V BY CROWN, PARRAMATTA

ACCESS REVIEW S75W APPLICATION

Morris Goding Accessibility Consulting

12th June 2012

Drawing Title
GROUND FLOOR

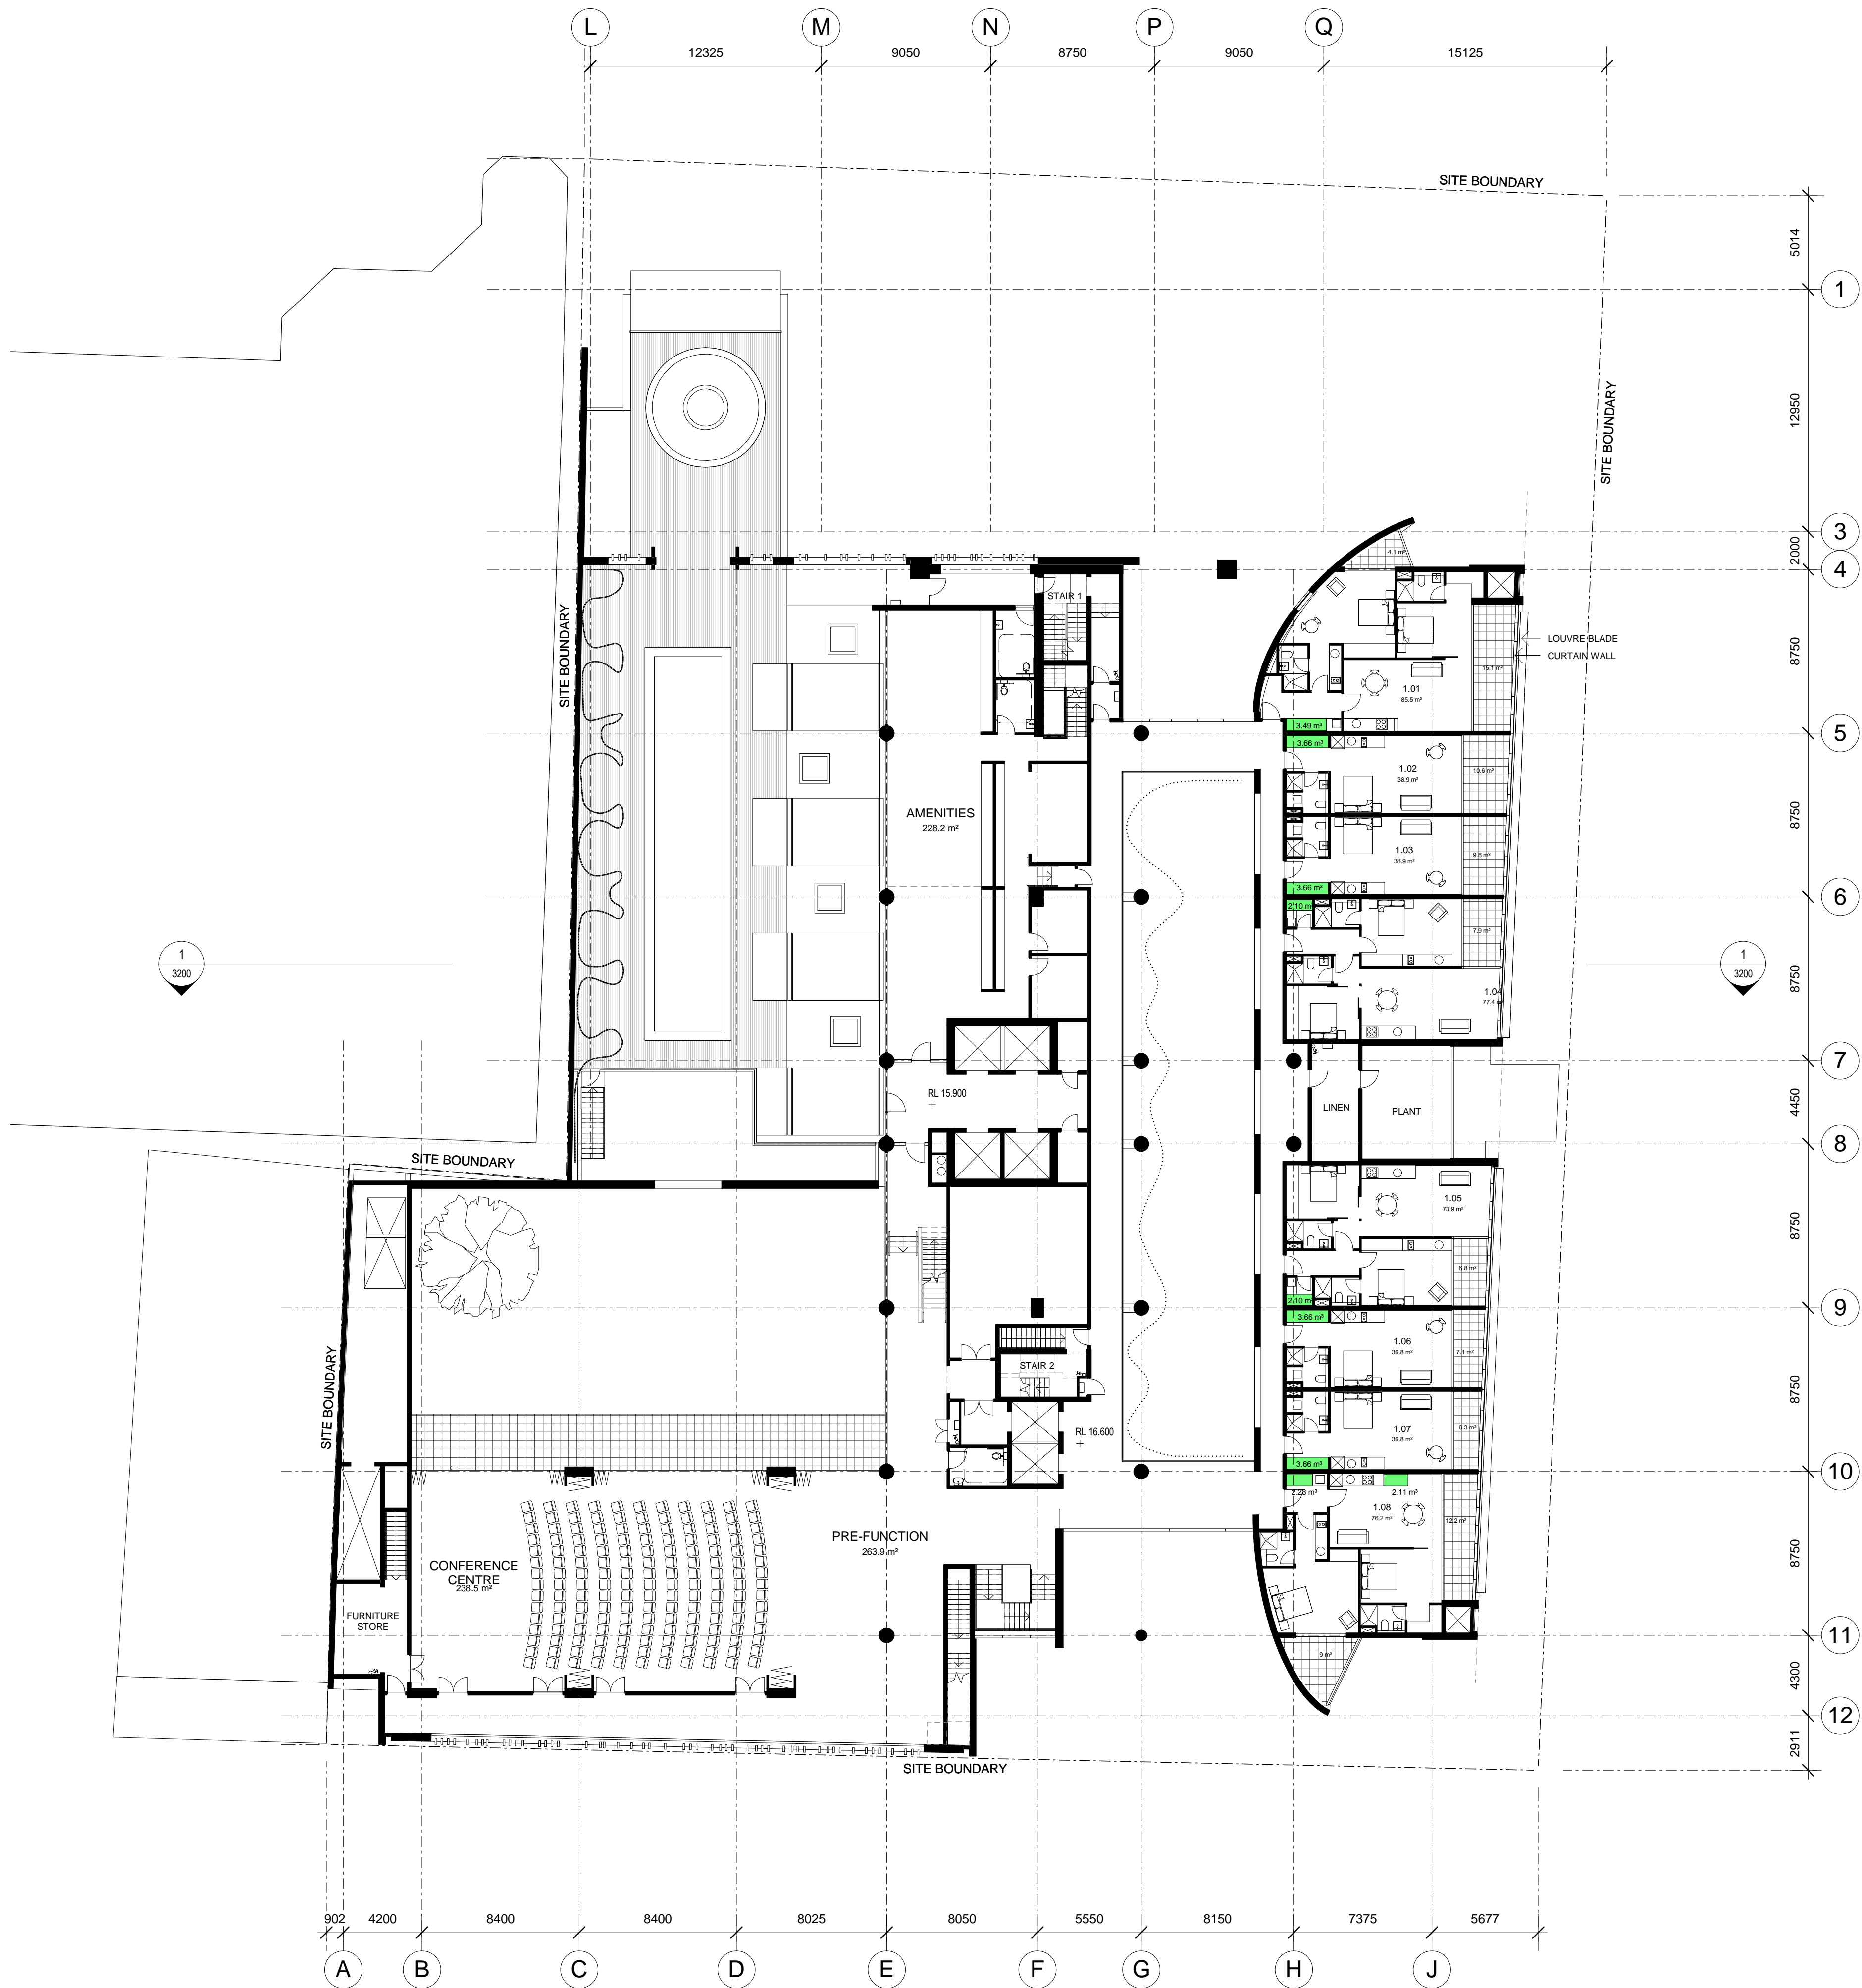
- (i) Provide handrails compliant with AS 1428.1 on either side of Macquarie Street and Marsden Street main entry stairway. Due to stairway width, intermediate handrails may be required to satisfy BCA requirements and assist people with ambulant disabilities.

There is a direct and accessible path of travel from Macquarie and Hunter Street entrances to the ground floor passenger lifts that serve the upper building levels. The Marsden Street entrance is however connected to the Lobby by an internal ramp with approx. 1:11 gradient which is inaccessible to people using wheelchairs. This requires review for compliance with the DDA Premises Standards which requires all ramps (excluding fire-isolated ramps) to be compliant with AS1428.1.

- (i) Ensure suitable walkway gradients (no steeper than 1:20 with suitable intervals) from site boundary to Lobby main entrances, compliant with AS1428.1.
- (ii) Ensure Marsden Street internal entry ramp has a max. 1:14 gradient ramp for 9m max. lengths, compliant with AS1428.1 and DDA Premises Standards.

Project
V by Crown, Parramatta
45-47 Macquarie St and 134-140 Marsden St
Parramatta
New South Wales
Proj No. 10052
Drawing Title
LEVEL 1

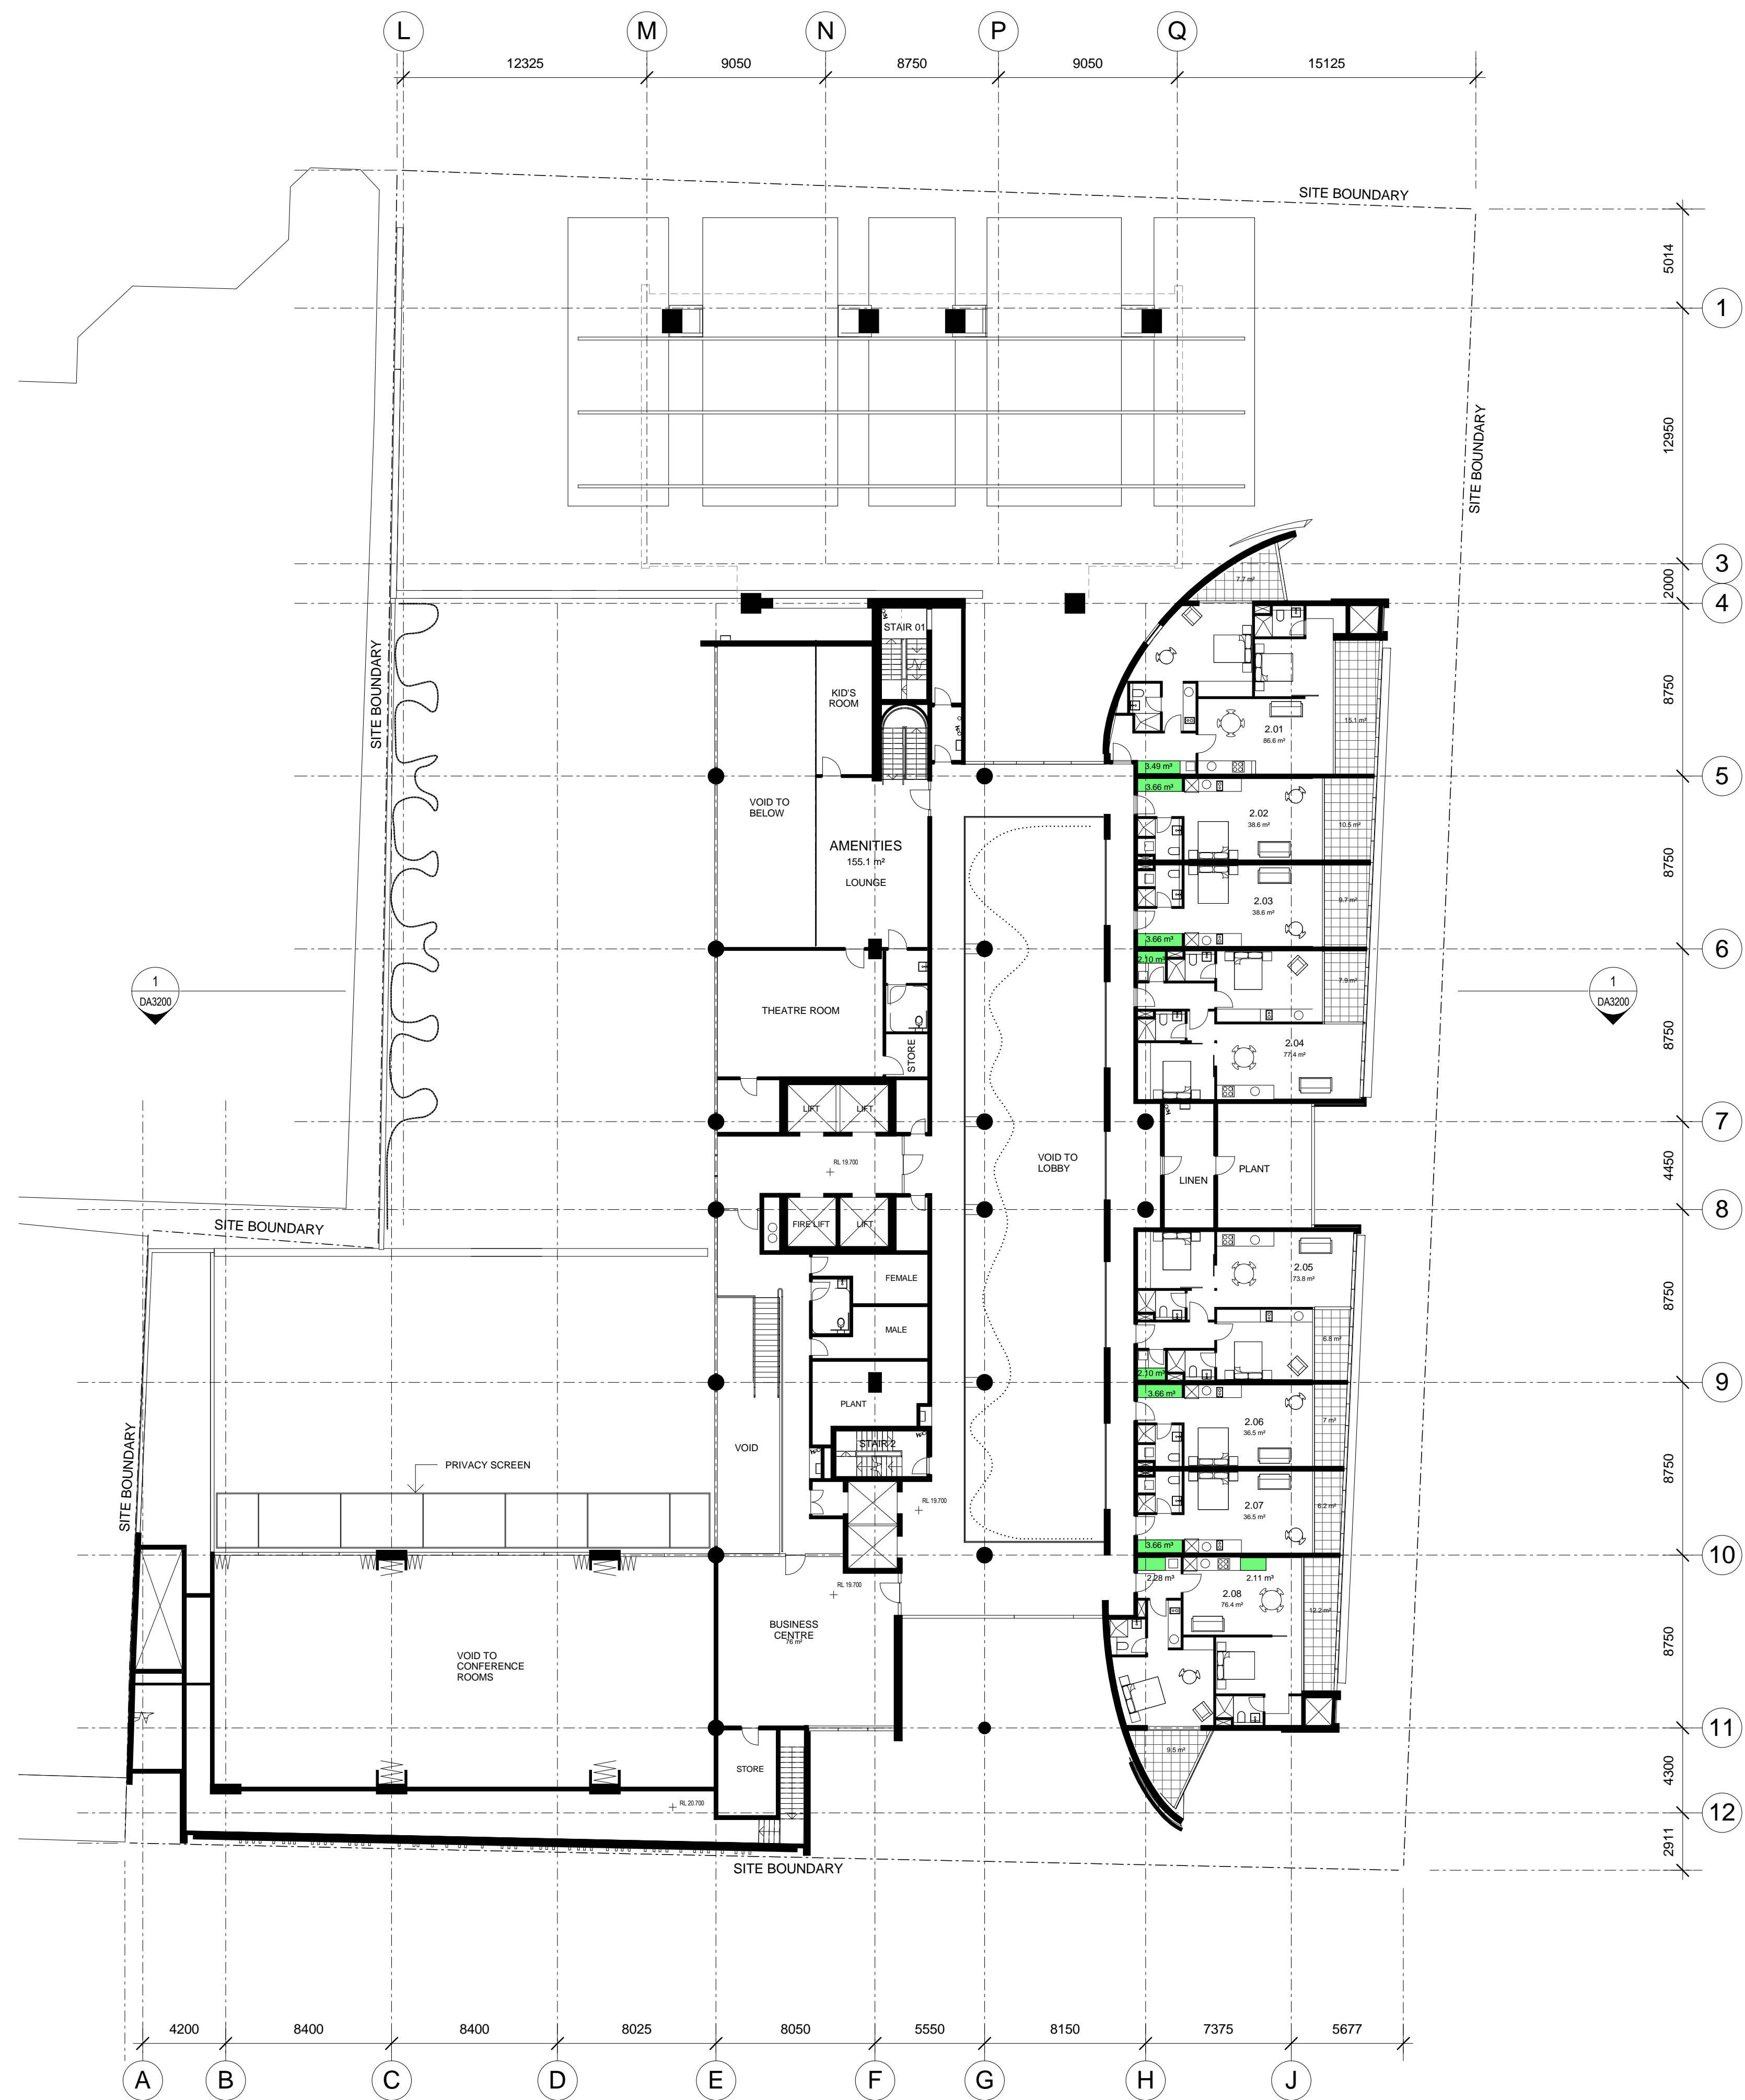
- (i) Provide handrails on both sides of the stair to level 1, compliant with AS1428.1.

- (i) Ensure all doorways have a minimum clear width of 850mm (920mm door leaf) and suitable door circulation area on both sides, compliant with AS1428.1.
